110 O'Connor Street | Informal Pre-consultation | Site Plan Control Application | Groupe Mach, Geiger Huot Architectes, Fotenn Planning + Design

Key Recommendations

scale :	As indicated	drawn by :	E.H.	
date :	date	approved by :	E.H.	
folder :	23-032	drawing :	A-200

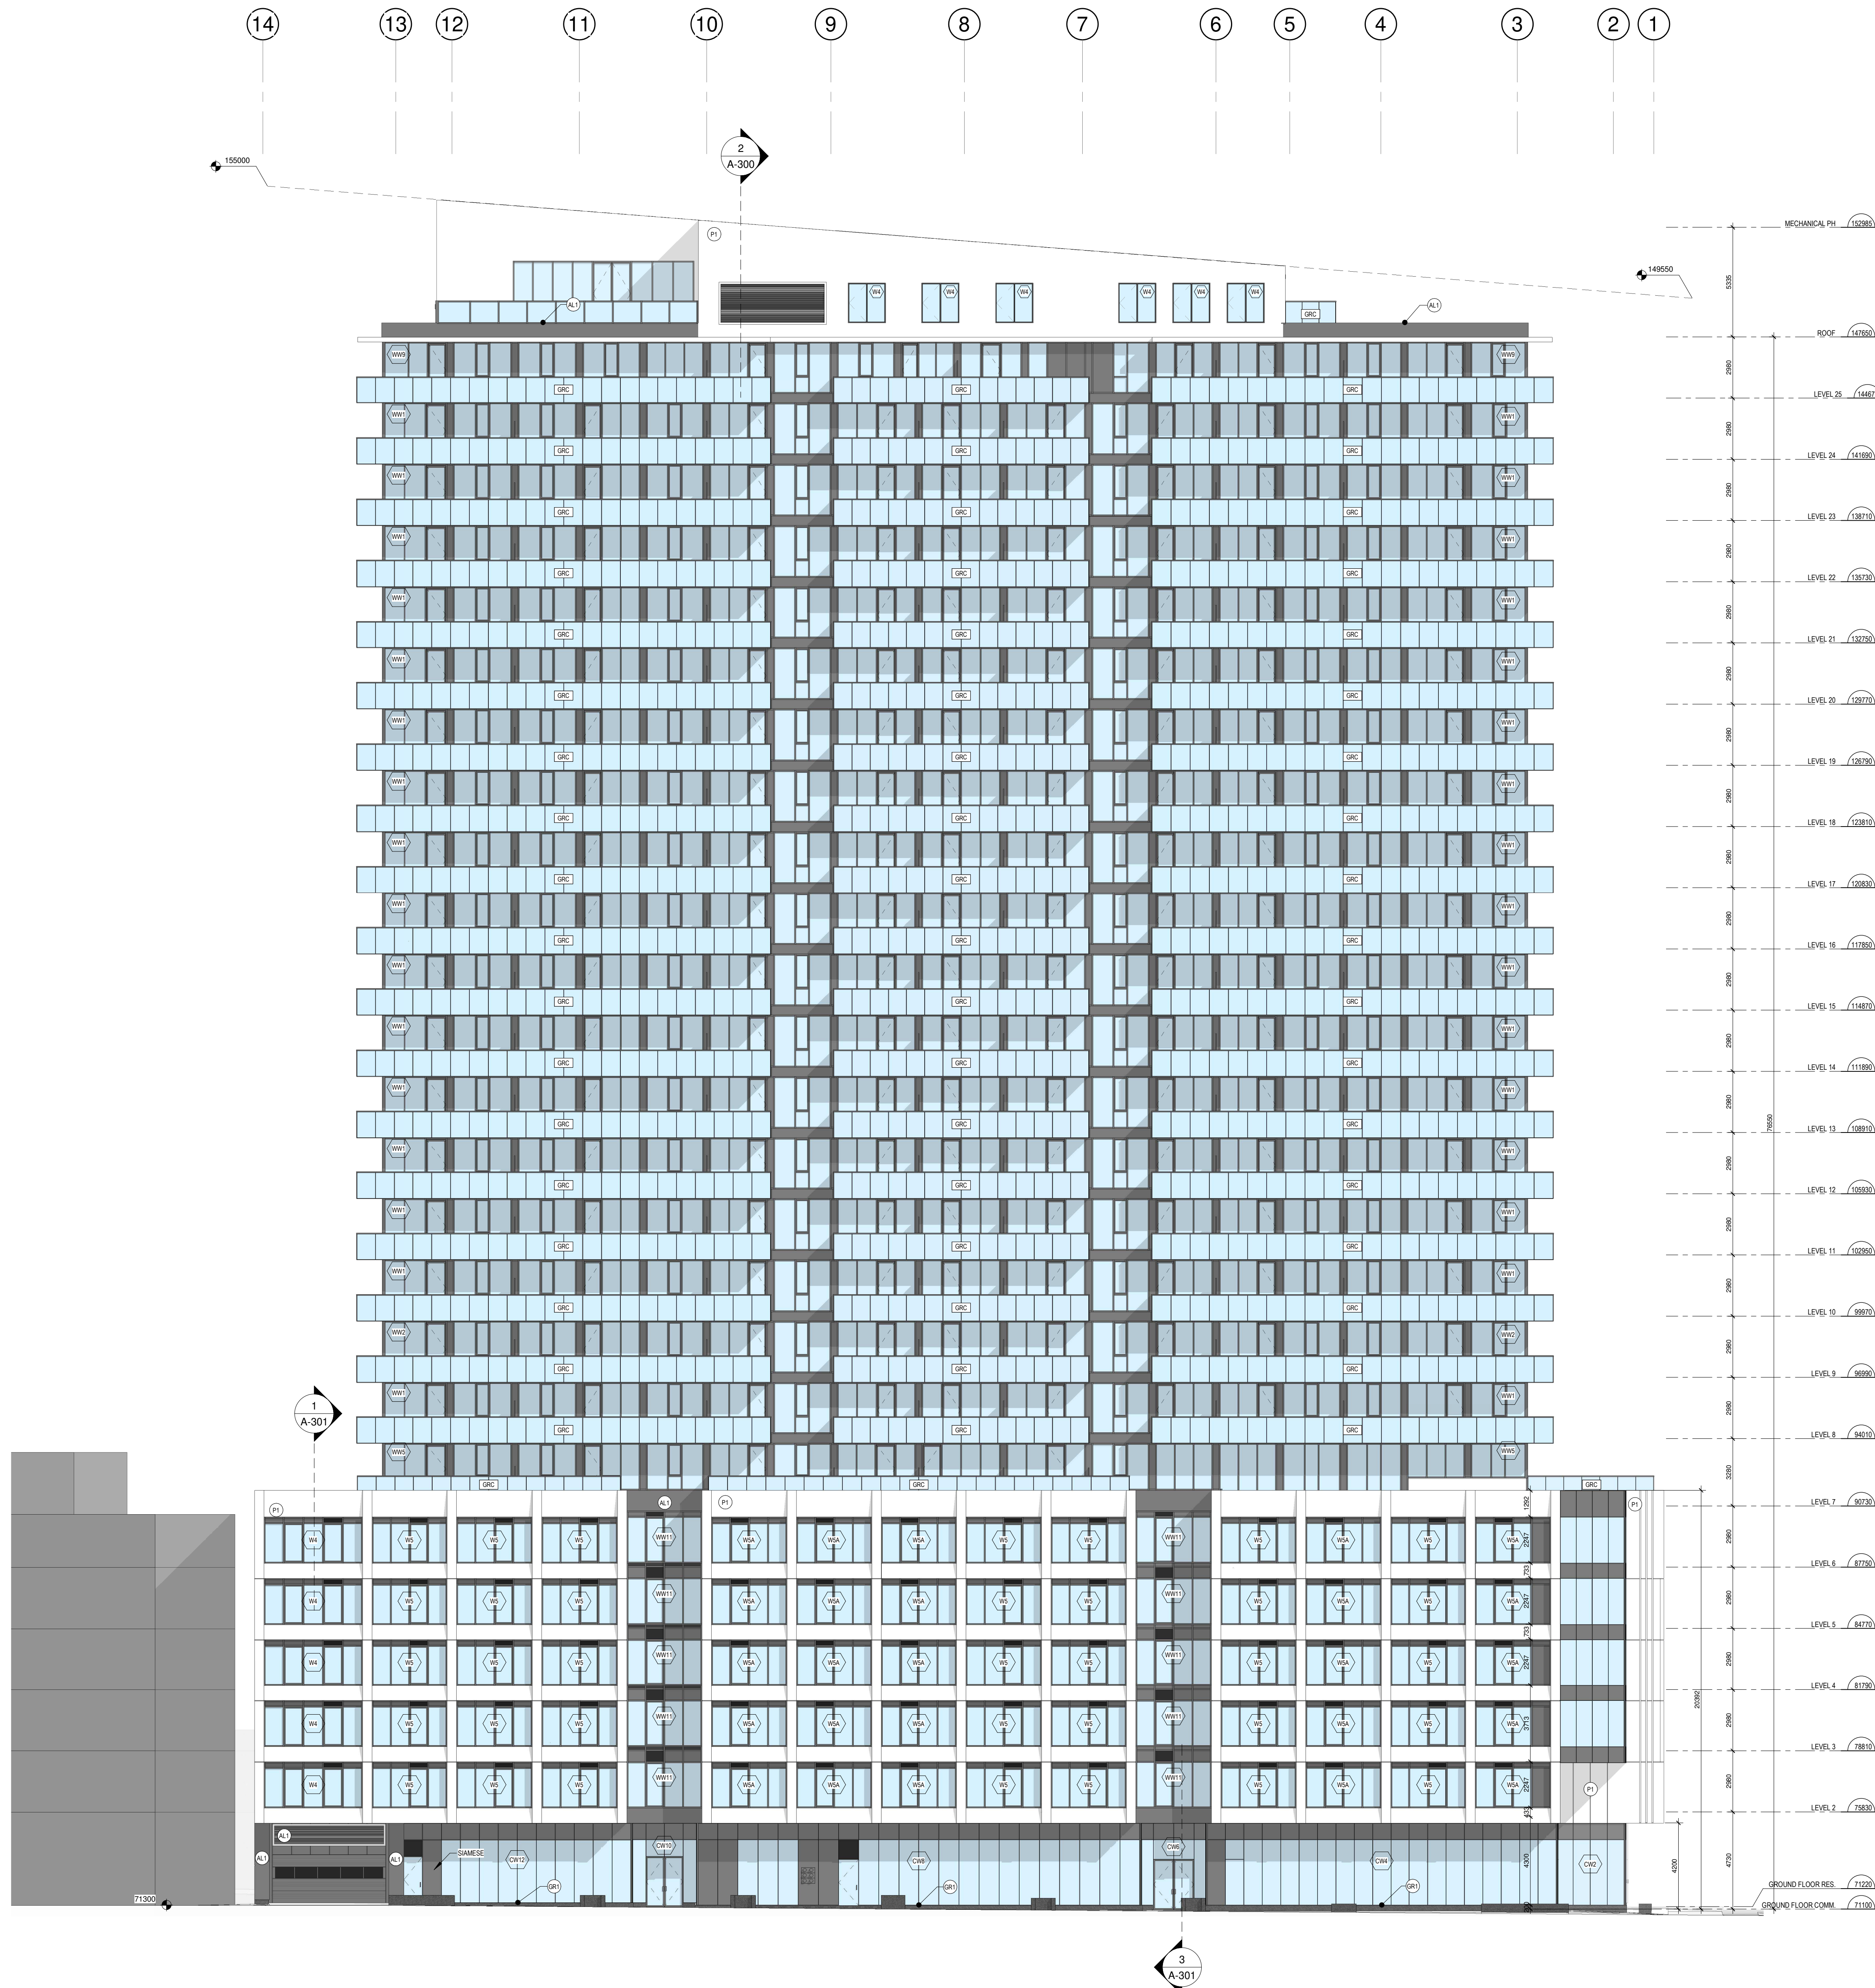
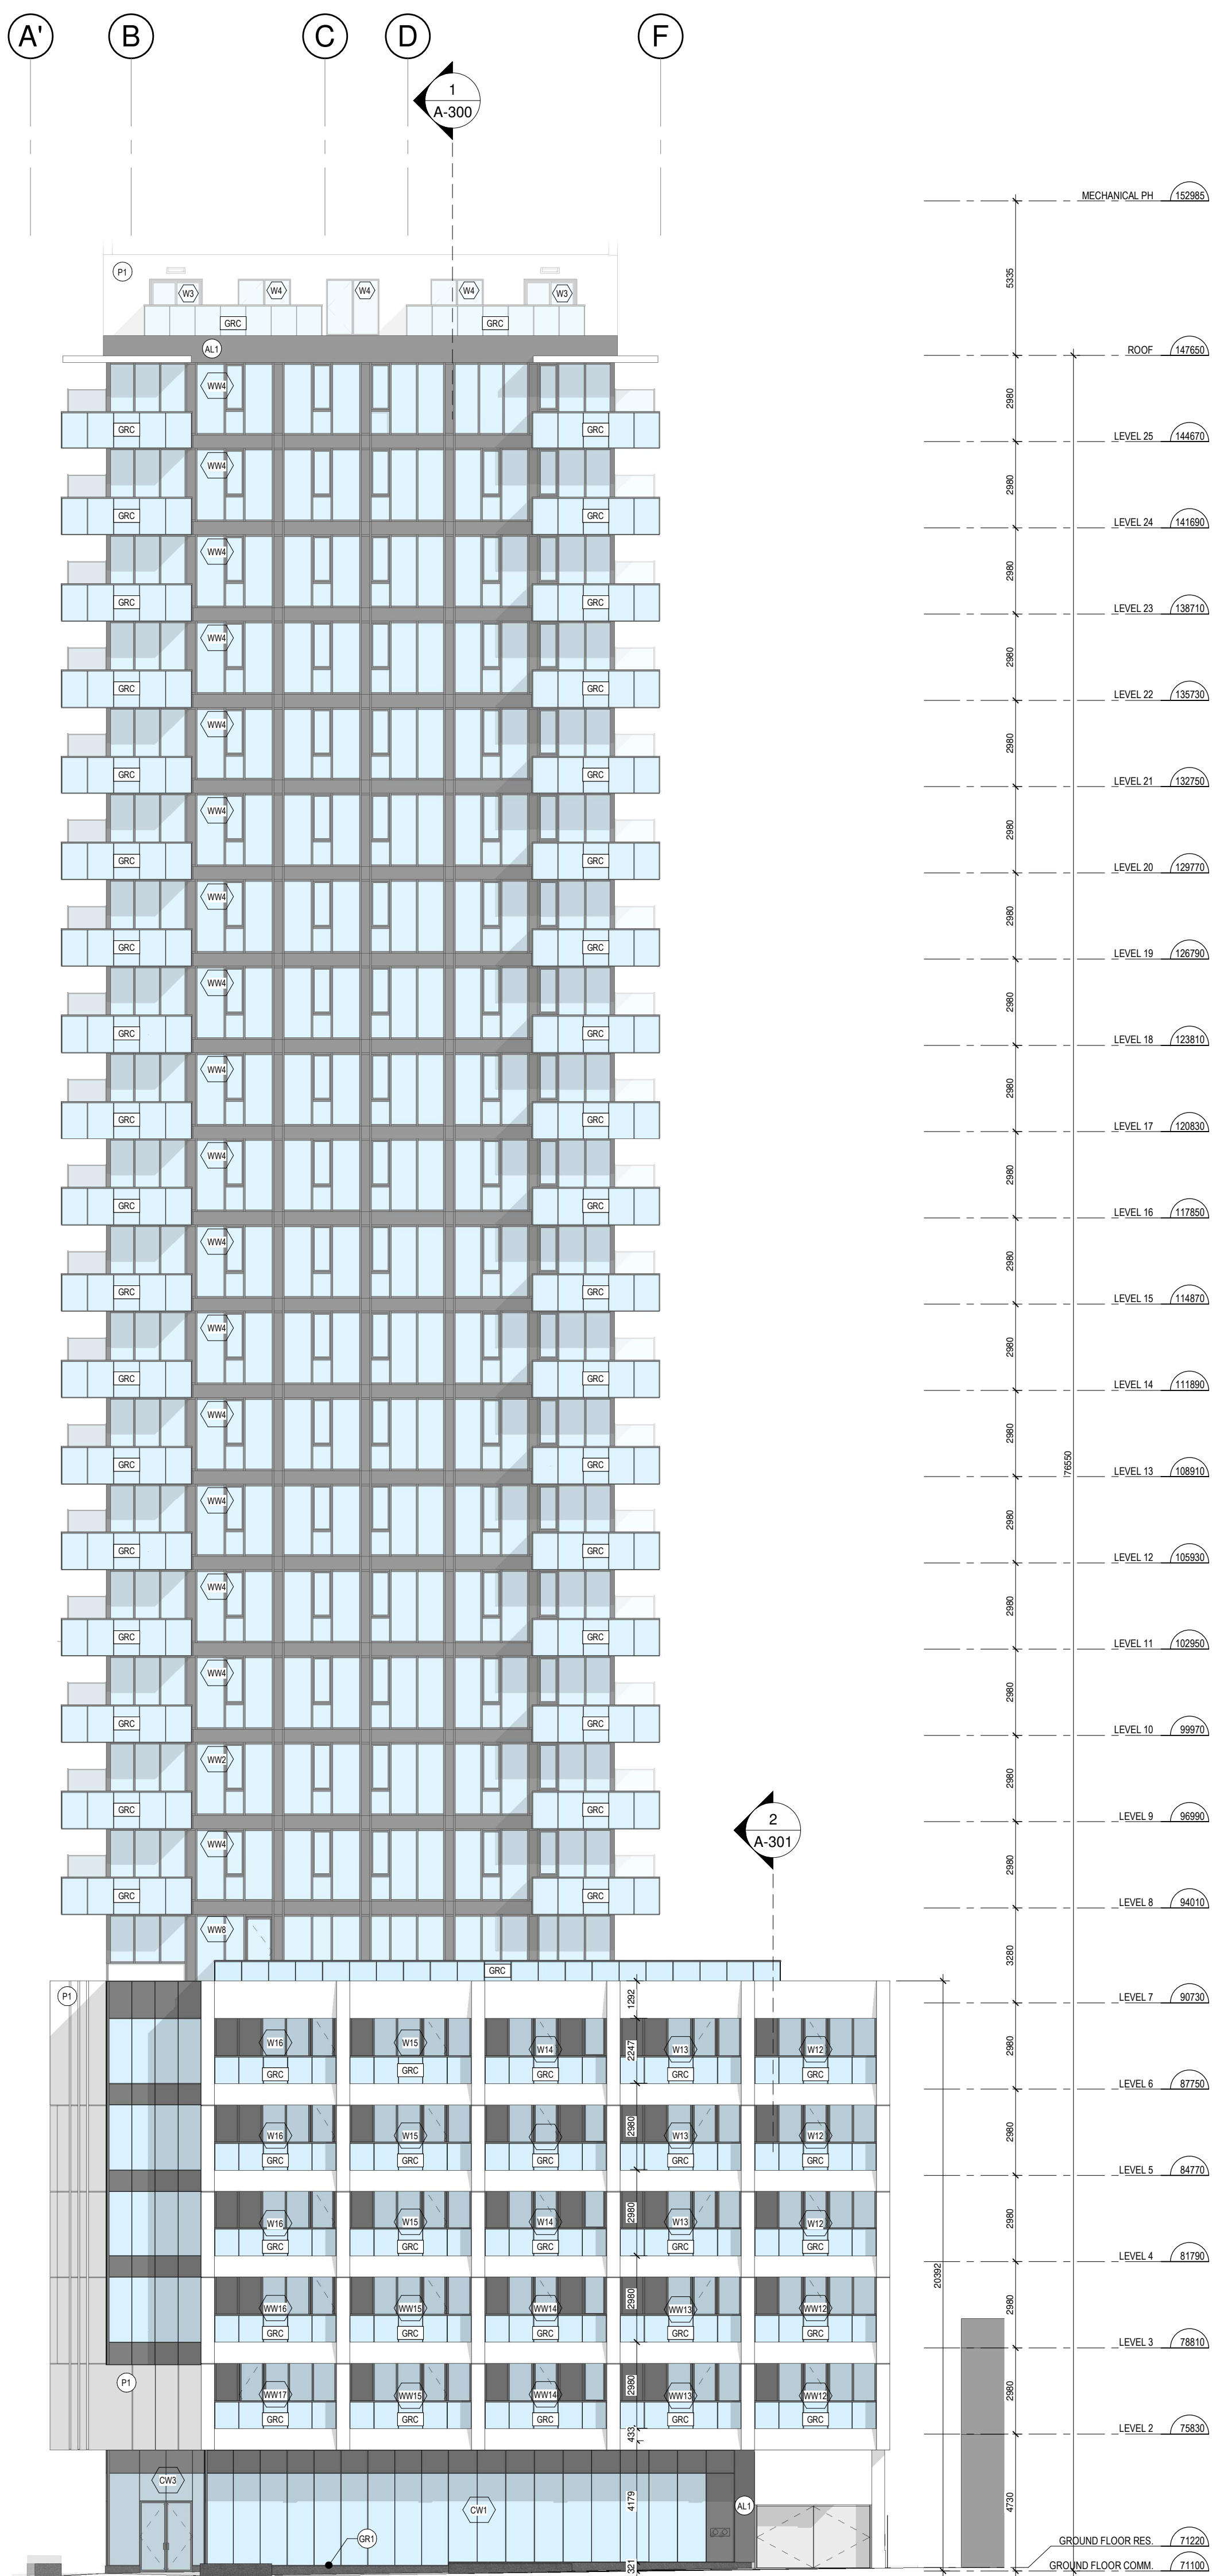
- The Panel has concerns with the heavy “looming” effect of the dark tower, especially in contrast to the lighter expression of the base. Consider pursuing a lighter tower expression that compliments a more solid expression in the podium base.

- The Panel has concerns with the use of cement board on the podium, and recommends using a more solid and durable material such as stone or precast panels.

- The Panel appreciates the highly glazed corner treatment at Slater Street and O'Connor Street, but recommends further detailing and highlighting that corner expression to form a feature and beacon for the building.

- The Panel has concerns with the cantilevered overhang being too close to grade-level and negatively impacting the access to sunlight on the ground floor and within the pedestrian realm, and recommends raising the cantilever by at least one storey (3m).
- The Panel recommends minimizing the use of large balconies on the tower.

- The Panel has strong concerns with how dark and heavy the current proposal appears. The surrounding context has a prevalence of light grey precast, stone, and glass materiality at its base with a similar or lighter glazed materiality palette above. The Panel strongly recommends considering a lighter glass materiality above a stone-clad podium for this development as well.

- The Panel has concerns with the cement board being proposed not meeting the more elevated finishes that are necessary in downtown. Consider the materiality of surrounding precedents such as the EDC building across the street and brutalist pre-cast buildings which contain intricate details and fine expression in their materiality.

- The Panel suggests that the corner expression of the proposal is particularly important to the overall success of the development. Consider a silicone glazed curtain wall with more lightness. The corner condition at Slater Street and O'Connor Street needs to become a more highly defined architectural space/feature.

- The Panel has concerns with the very long balconies being proposed, and recommends further study is needed on the balconies and how they integrate with the building expression.

- The Panel has concerns with the lack of articulation in the tower and the resulting 'canyon effect'.
